From: Zac Denton
Sent: 27 February 2019 10:33
To: [REDACTED]
Subject: RE: A/3/19/L - Weavers, High Street

Regarding the above application, do you have any details relating to the glass screen, proposed in the bathroom of the development? *E.g is it fully frames, glazed, what colour is it etc.*

Date	Scale	Job No.	Drawing No.	Revision
NOV 2018	1: 50	1859	01

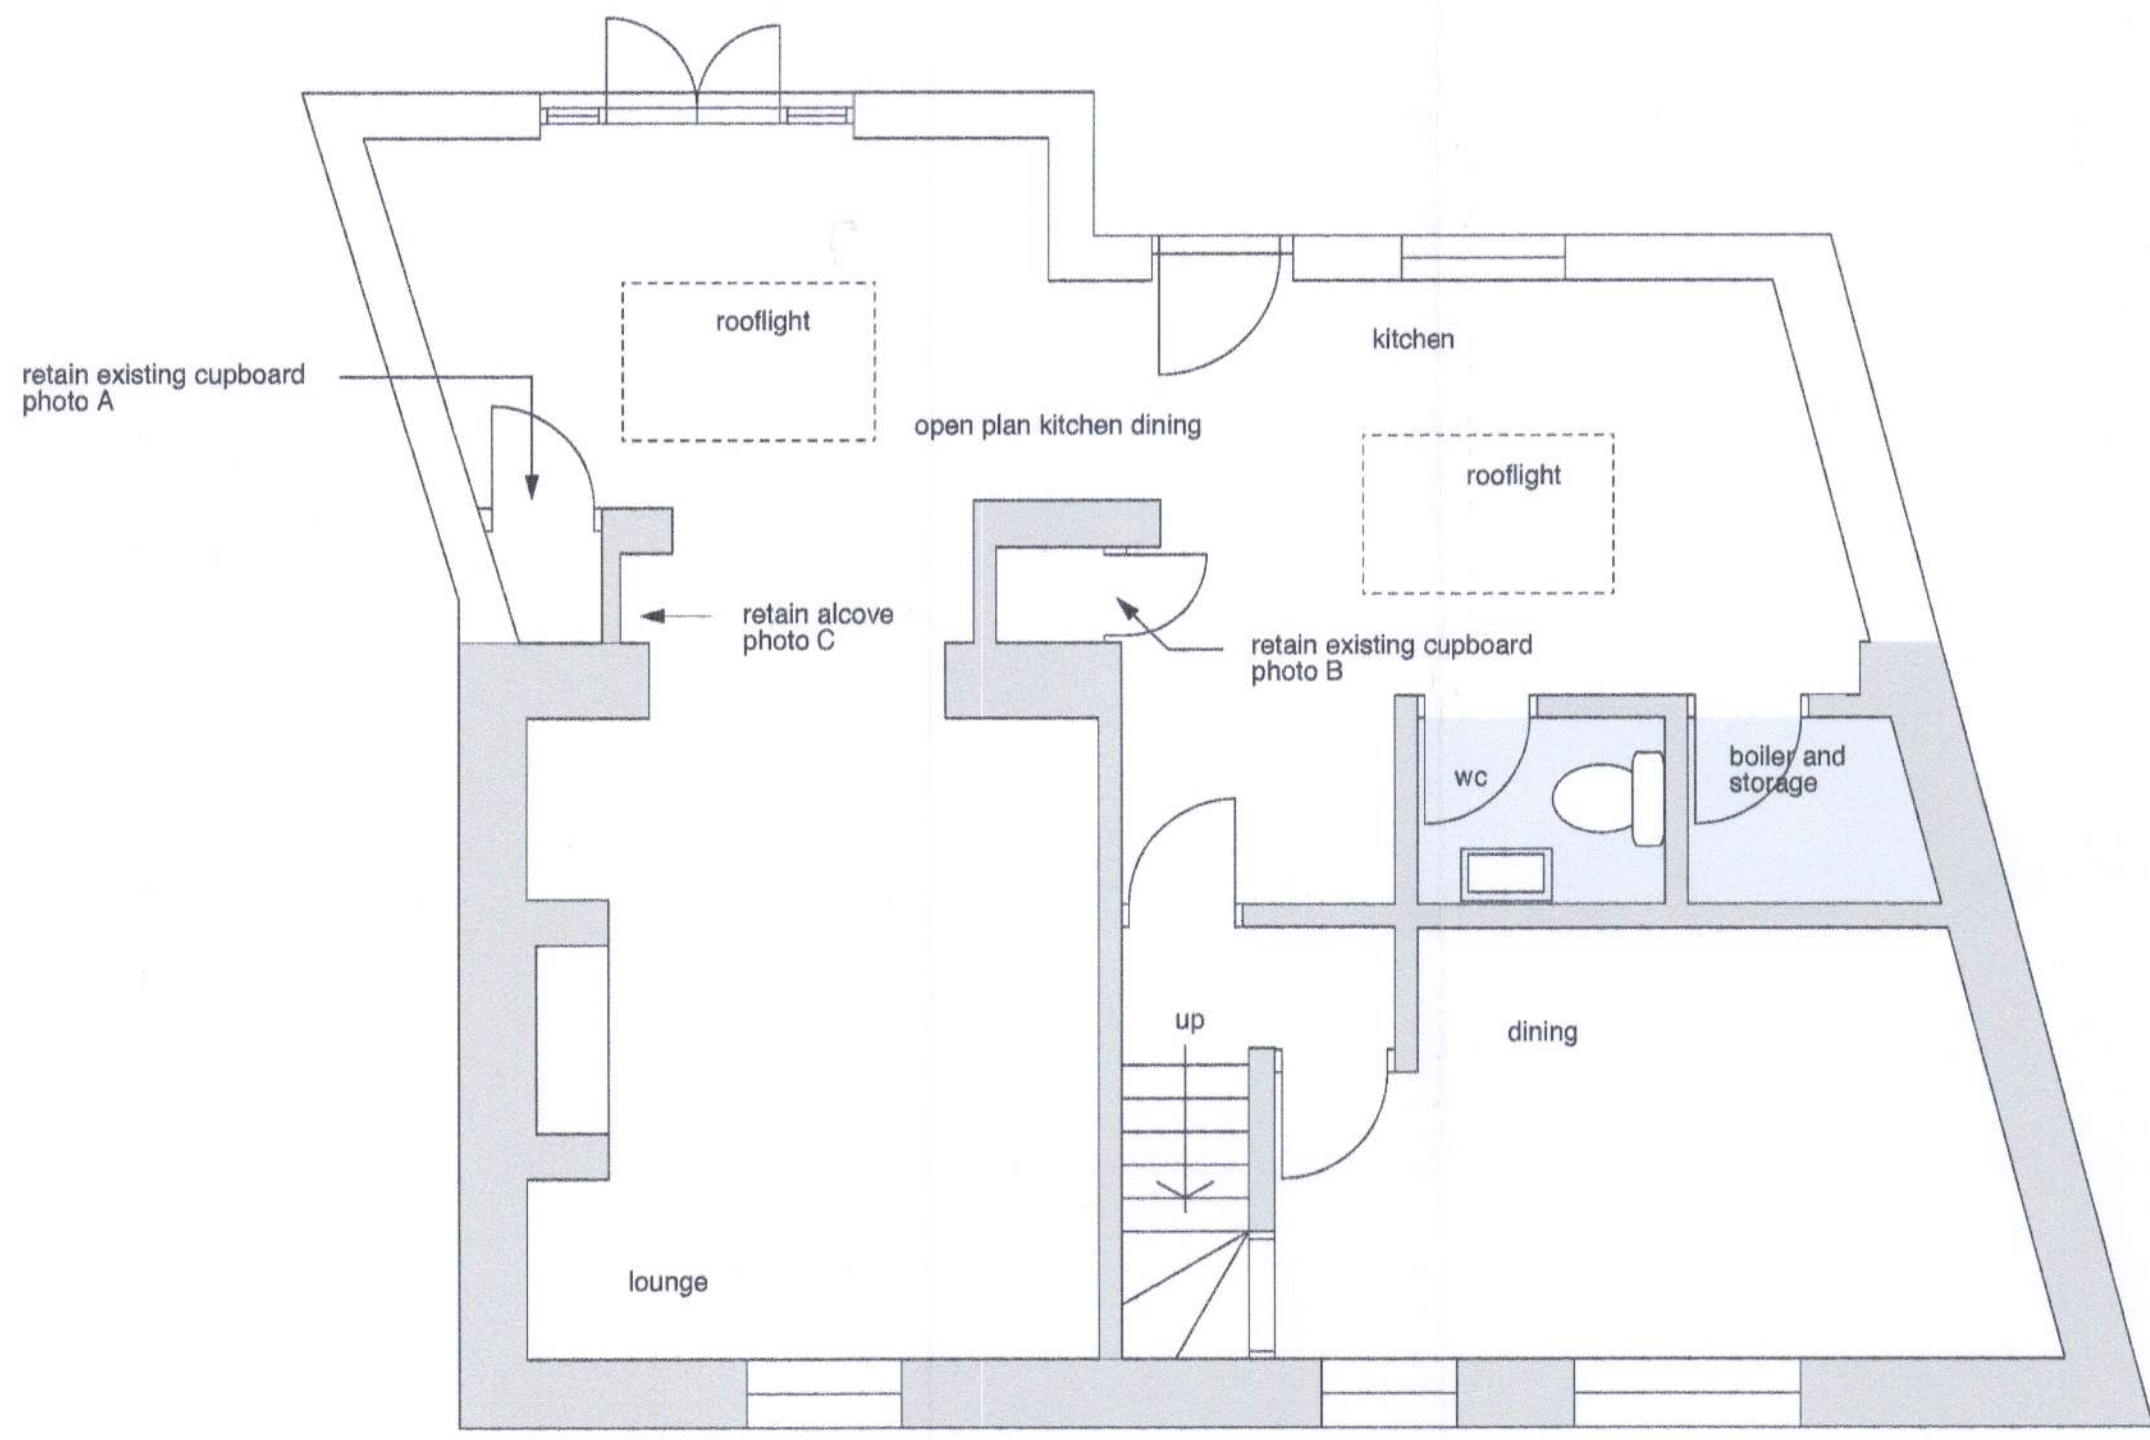
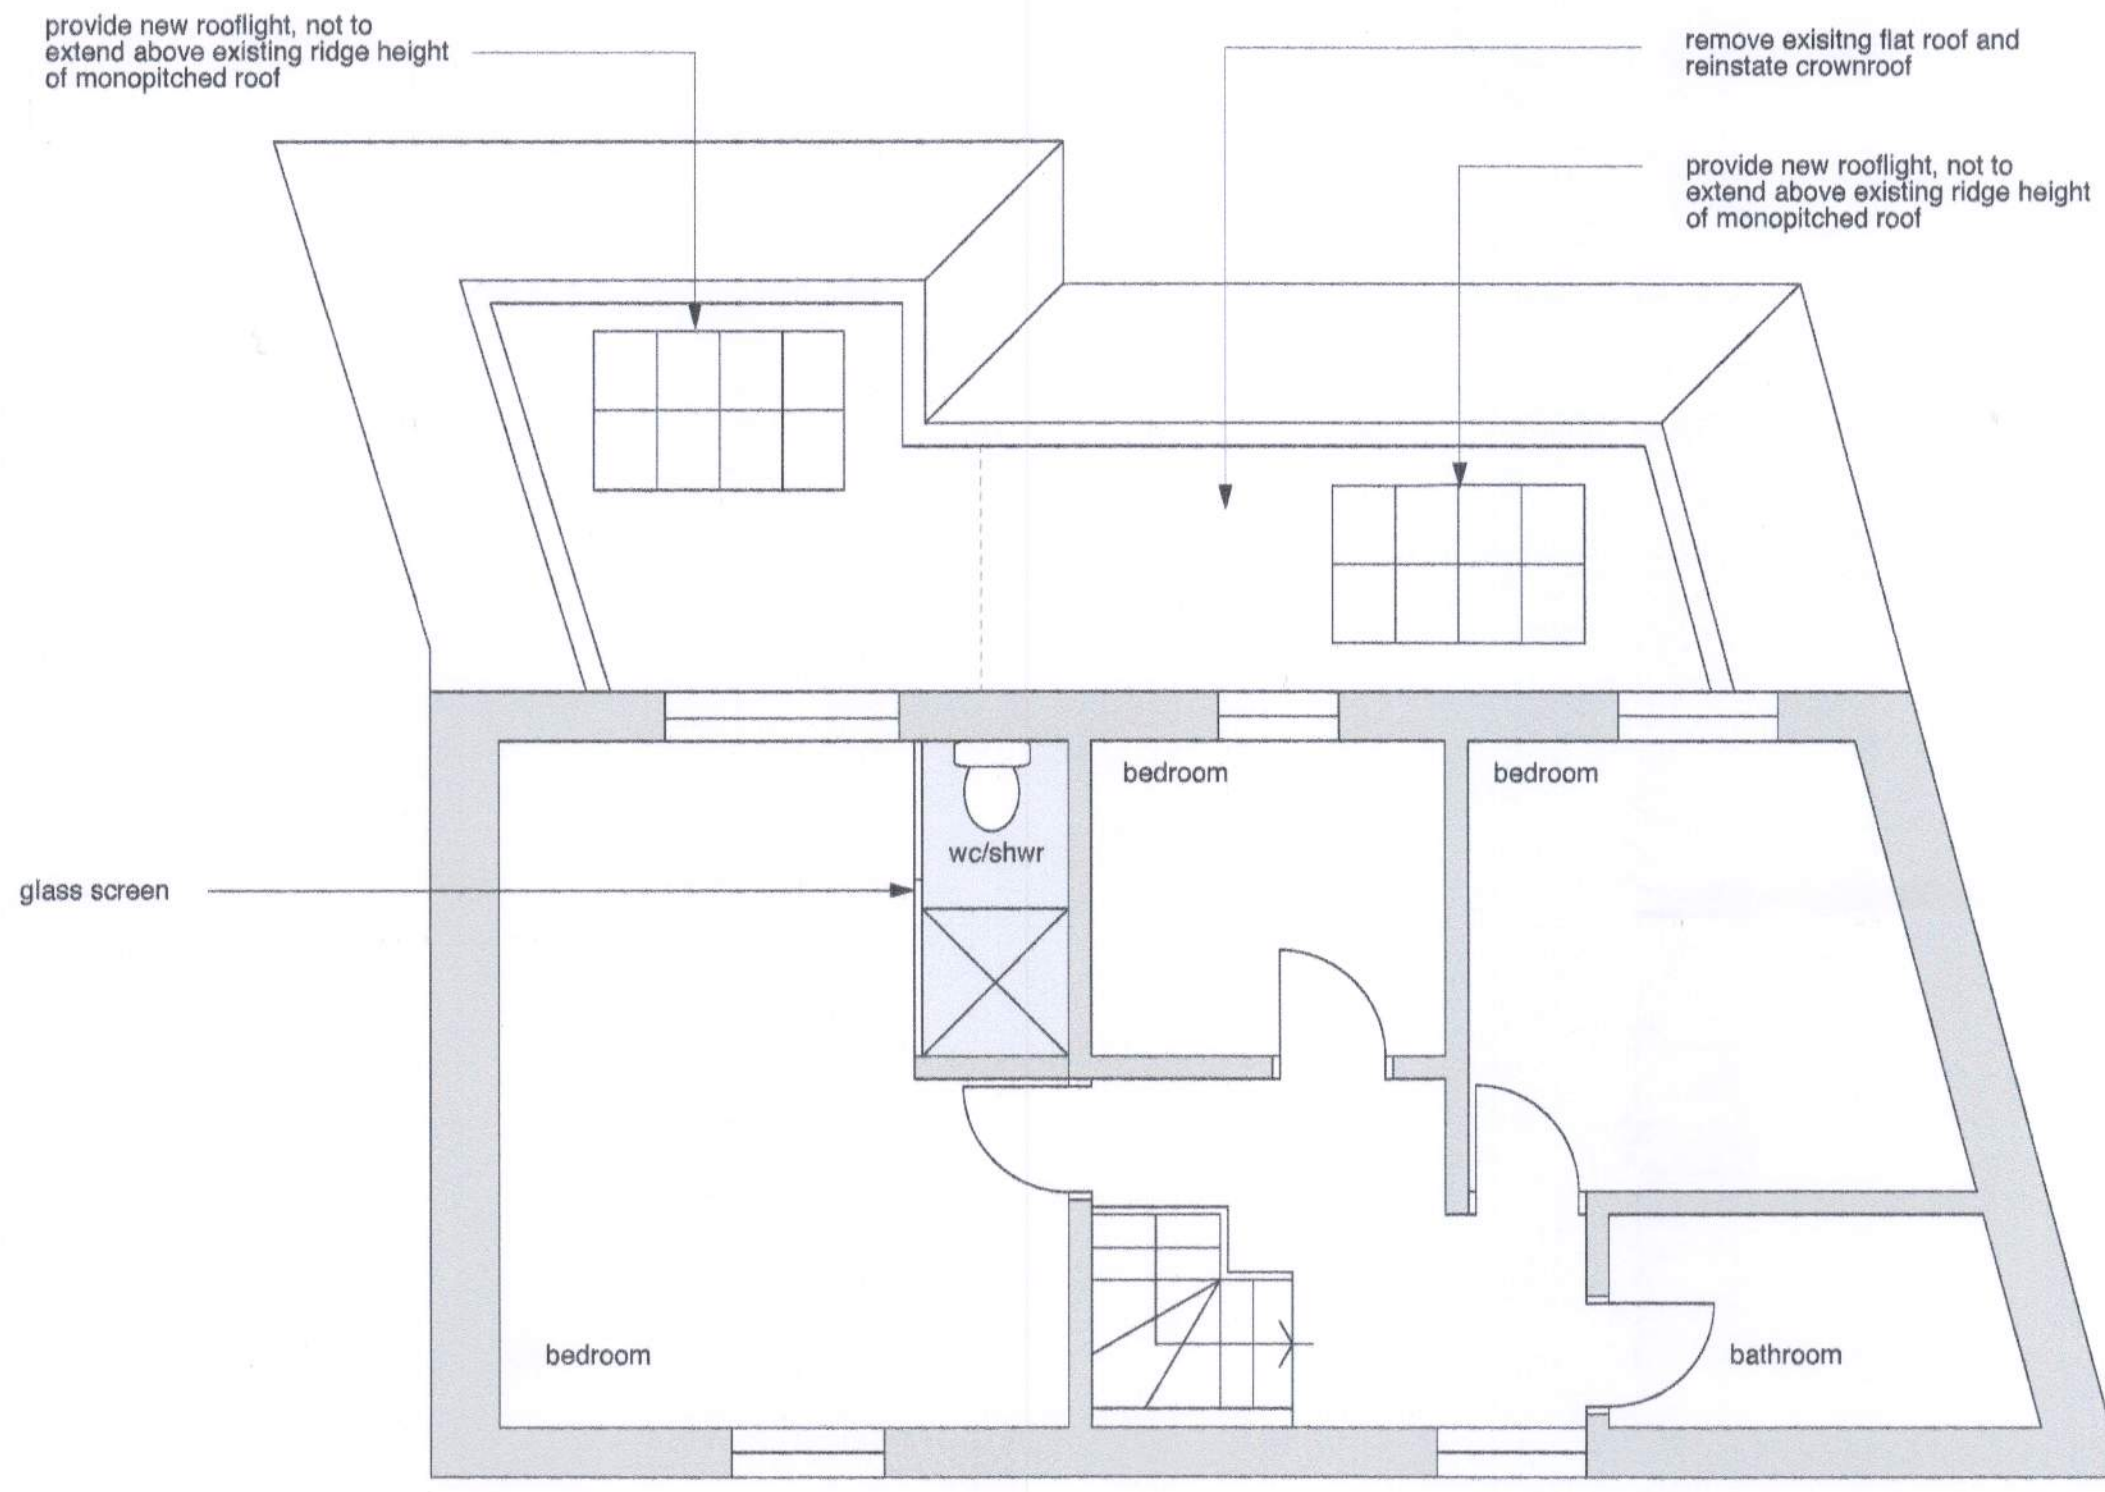
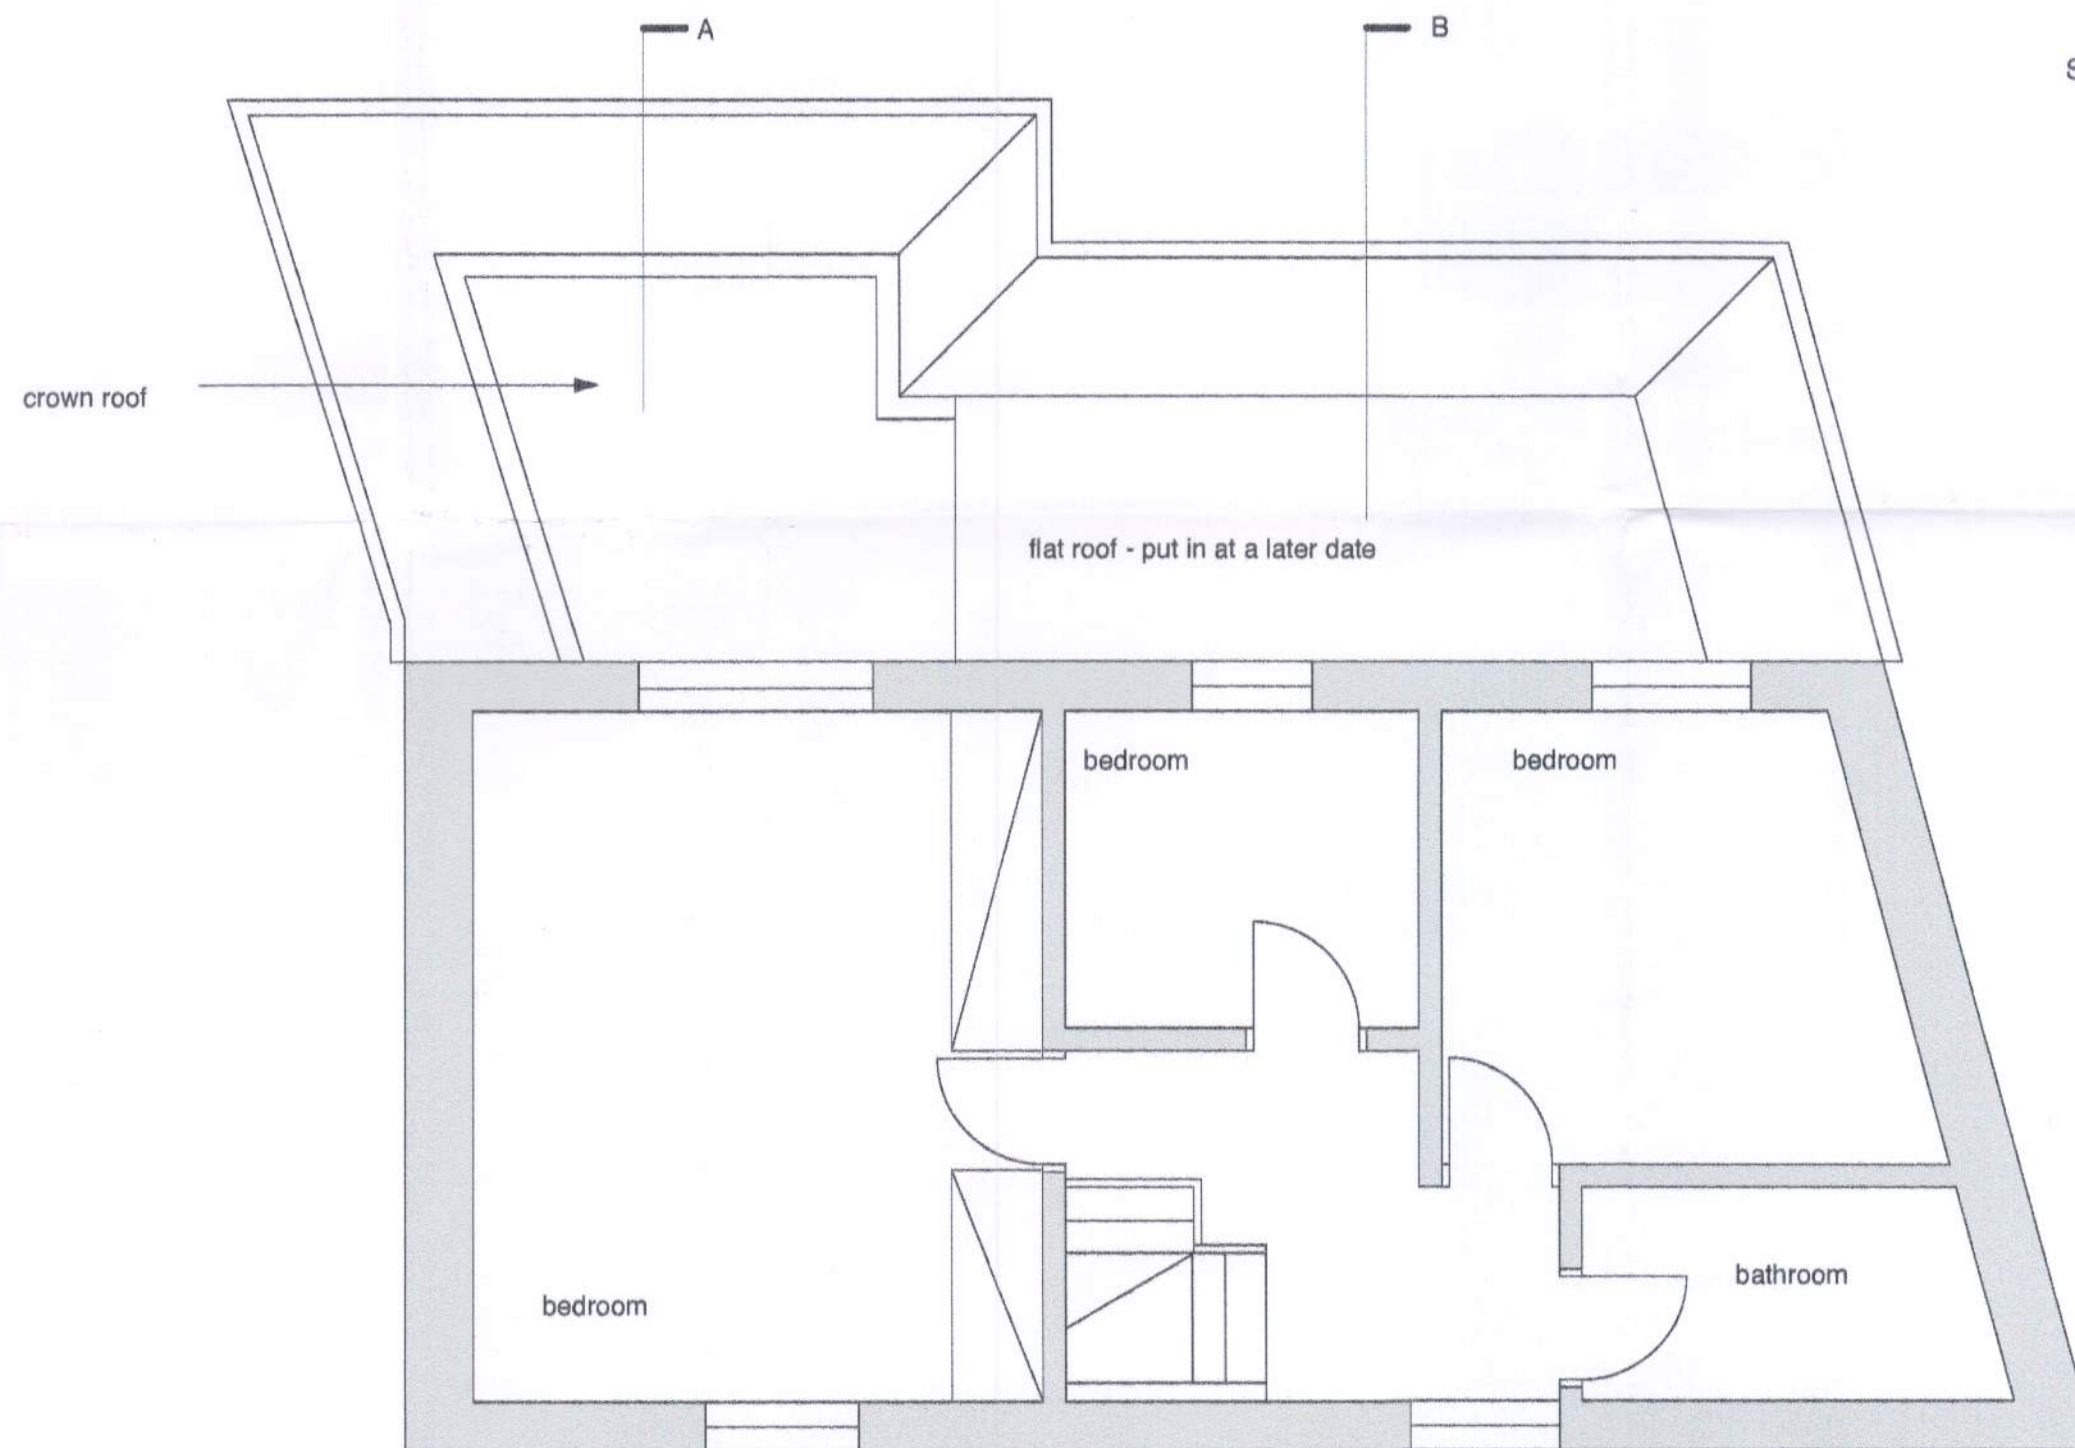
Do you have any further information? Relating to its physical appearance, size etc.?

If you have any drawings/sketches then this also may be useful.

Yes the glazed panels will fit within a s/w timber frame which will be painted white.
